Deadline VIII Submission (29th Feb 2016)Comments on ExA's draft DCO

Comments on information received at Deadline VII

Drawing title ENVIRONMENTAL MASTERPLAN  
REGULATION 4(2)(e)  
SHEET 30 OF 61 PALEY  
STREET FARM OVERBRIDGE

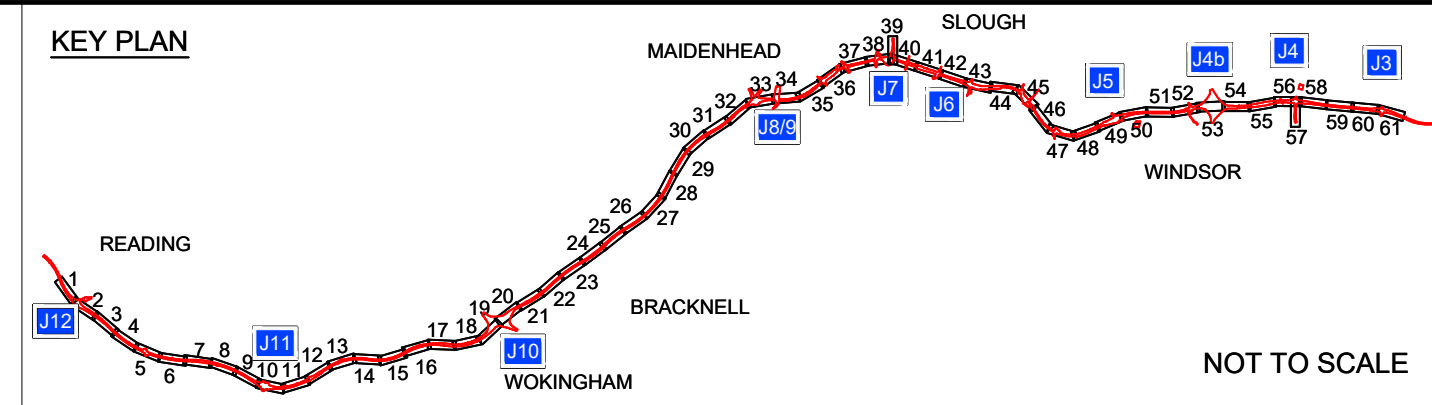
| <p>Enhanced Noise Mitigation Strategy; Cranford Park</p> | <p><u>Document ref. 514451-MUH-00-ZZ-RP-EN-400158, Enhanced Noise Mitigation Study Rev 7R</u></p> <p>Clause 2.19 explains the rationale behind the specification of a range of acoustic barrier heights.</p> <p>The barriers within the Hillingdon section of motorway commence with</p> <p>p) EM32 at the Harmondsworth end, where a 3m barrier is recommended.</p> <ul style="list-style-type: none"> • Clause 2.19, p. 8, r) EM34 recommends a 2.5m high acoustic barrier. • Table 1, p.13, Barrier Specification by Area, refers to EM34 (St Pauls) as a new 2.5m barrier / length 323m. |

| | <ul style="list-style-type: none"> • Table 1, p.14, Barrier Specification by Area, refers to a second EM34 (Cranford Park) as a new 2.0m barrier / length 570m. , • The Environmental Masterplan (sheet 30 of 31) annotates only one EM34 barrier as a 2.0m high barrier to the south of the motorway / north of Cranford Park. <p>The above information is unclear and inconsistent. If two separate barriers are proposed with different heights, there is a need for an EM35 with its own specification.</p> <p>It is still considered that a 2.5m high acoustic barrier is necessary adjoining Cranford Park to provide dual benefits of noise reduction and improvements to the visual amenity of park users.</p> |

| Environmental Masterplan drawings; clarification | <p><u>Plan ref. Environmental Masterplan (sheets 27 Rev 10F, 28 Rev 9F, 39 Rev 9F and 30 Rev 9F of 31)</u></p> <p>The main amendments are in the form of recently proposed acoustic 'barrier information' summarised in the orange / brown roundels and the additional grey roundels which highlight local environmental objectives. - As a general point, the legibility of the plans is hampered by the colours used in the key to the 'Environmental Elements-Landscape', where the shades of green used to represent different vegetation typologies are close enough to be misinterpreted.</p> <p>Barrier Information (graphical errors):</p> <ul style="list-style-type: none"> • Sheet 27, ch. 15600.00, annotation ref. 'EM32 / 3.0m / reflective' refers to a barrier detail and should be coloured brown, • Sheet 29, ch. 12250.00, annotation ref. 'EM33 / 3.5m / reflective' refers to a barrier detail and should be coloured brown • Sheet 29, ch. 12650.00, annotation ref. 'EM34 / 2.5m / absorptive' refers to a barrier detail and should be coloured brown, • Sheet 30, ch. 11750.00, annotation ref. 'EM33 / 3.5m / reflective' refers to a barrier detail and should be coloured brown. |
